Application ref: BR/131/20/PL

PROPOSED FLOOR PLANS

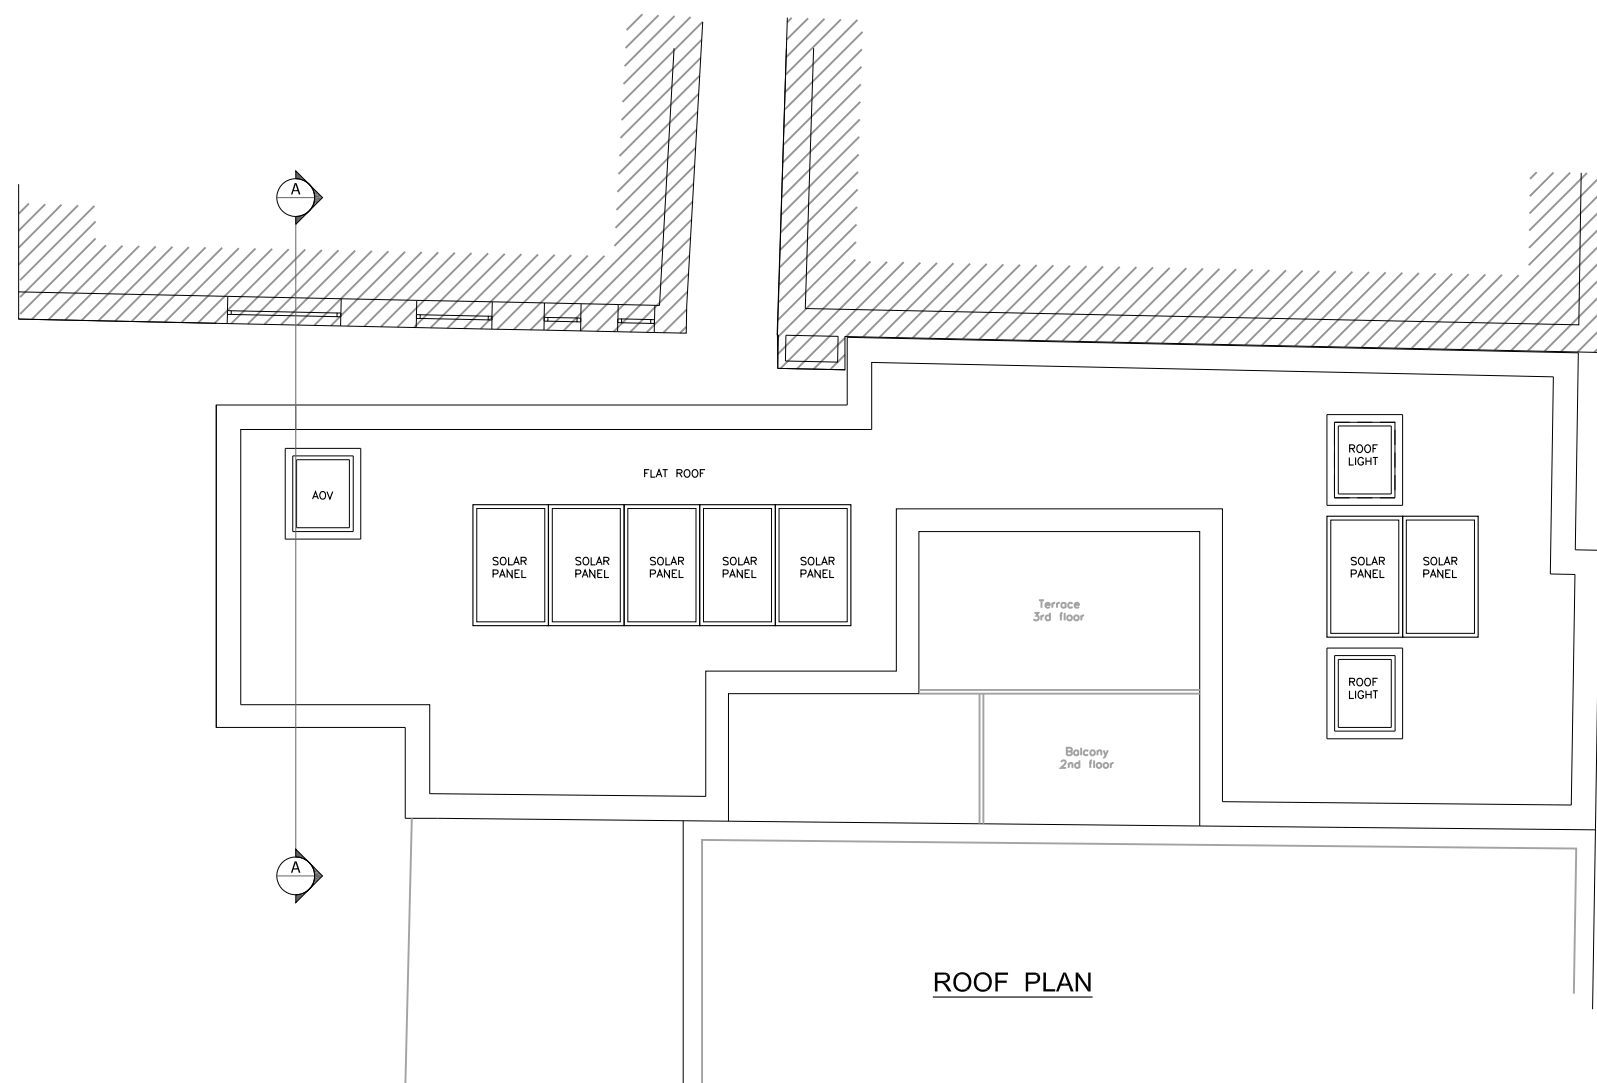
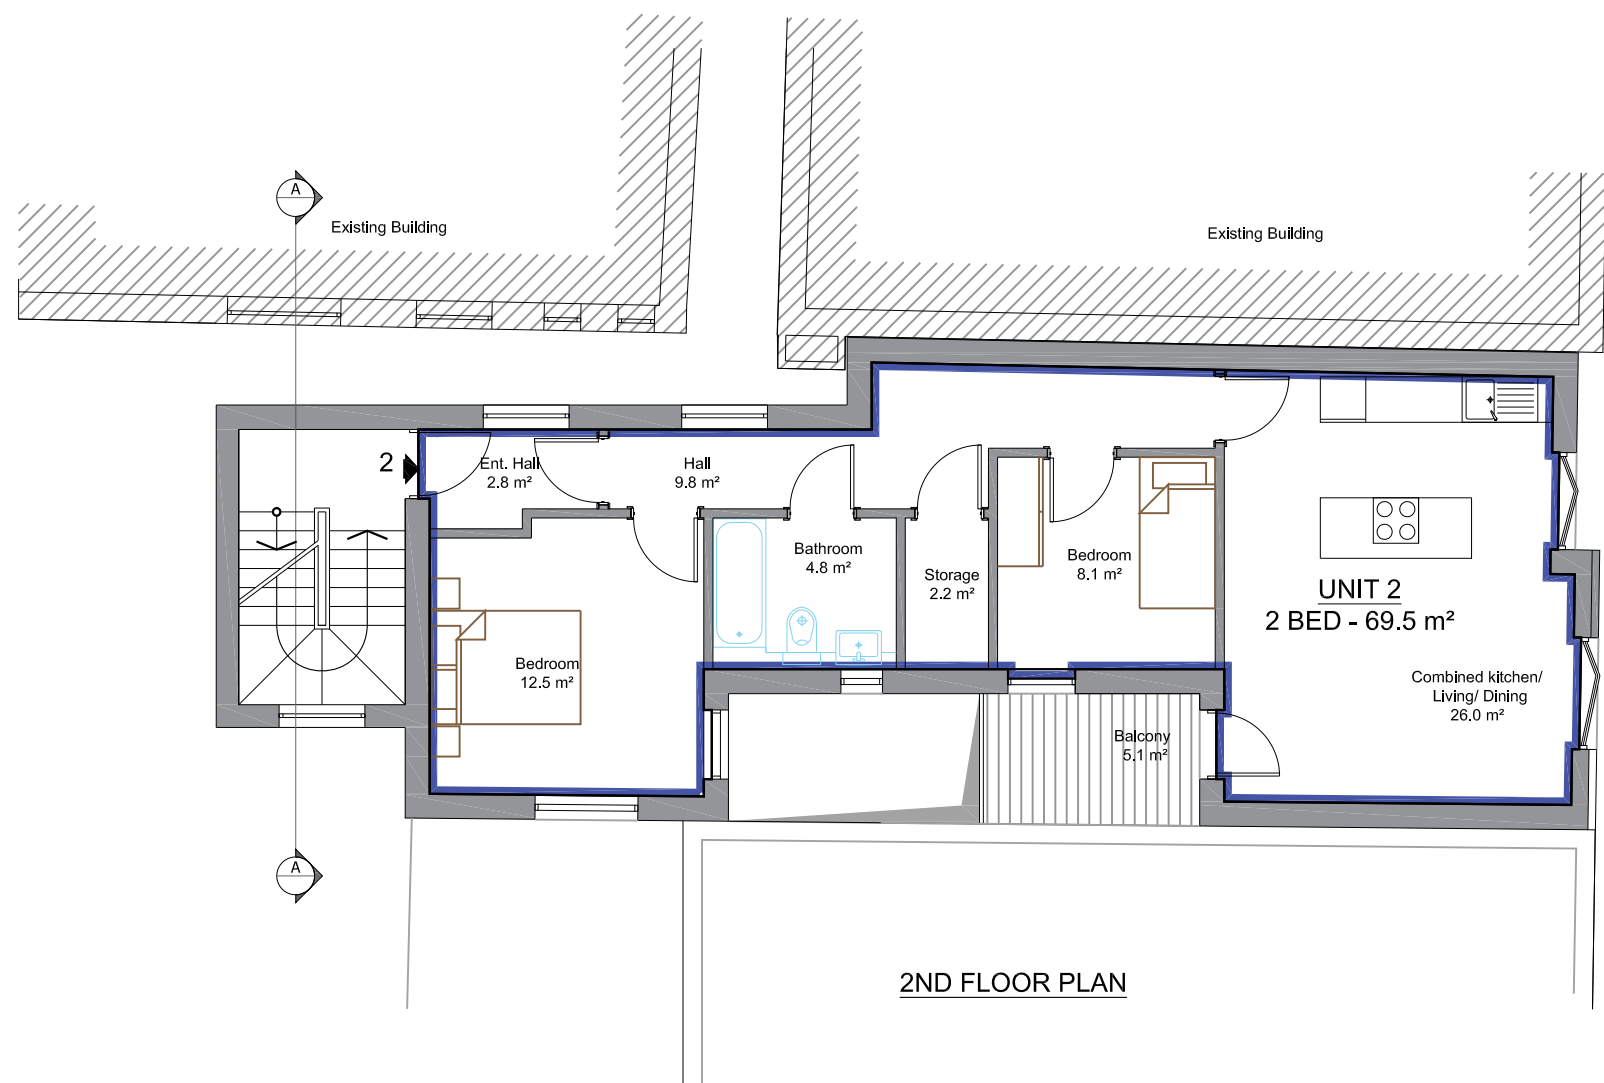
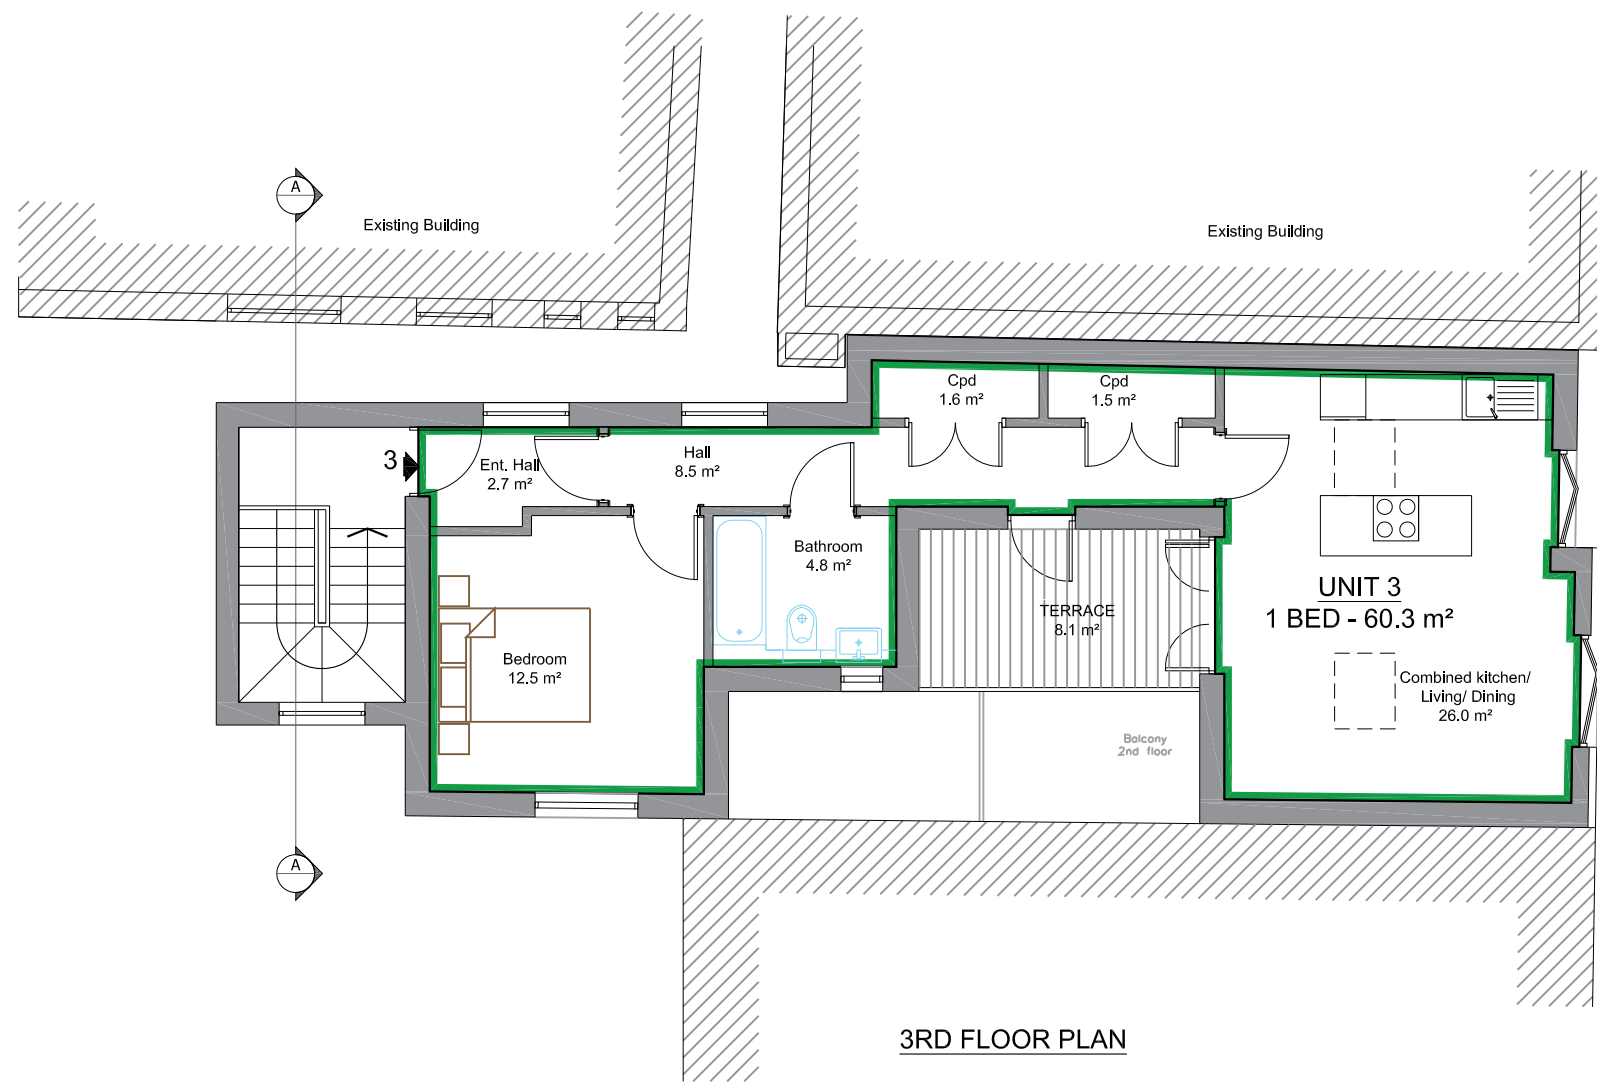
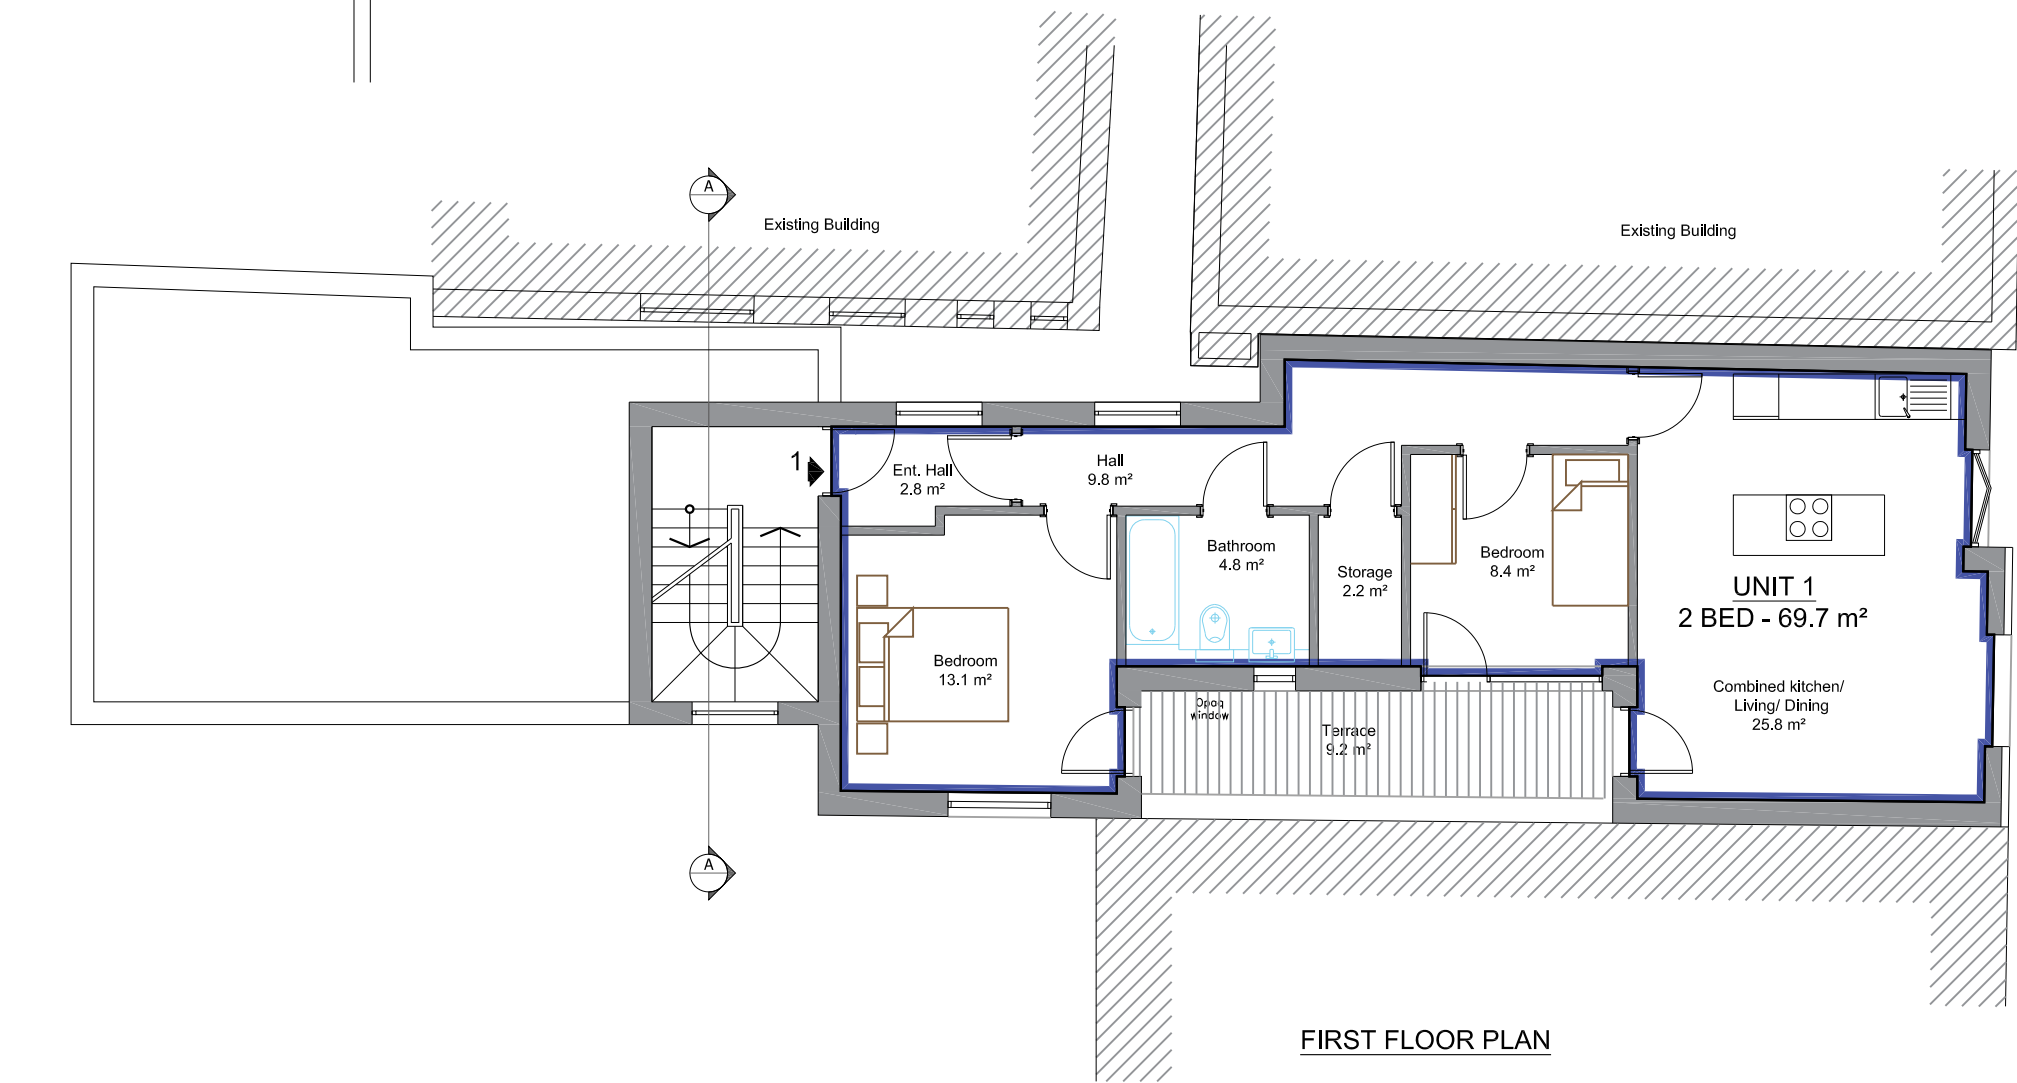
I act on behalf of Santander bank who occupy no. 42 High Street, Bognor Regis. Santander use the roadway at the rear of their branch as a fire escape and bin store. The above application proposes to build onto this roadway and thereby block Santander's emergency escape route. I object to this planning application on safety grounds and I urge the Council to reject it.
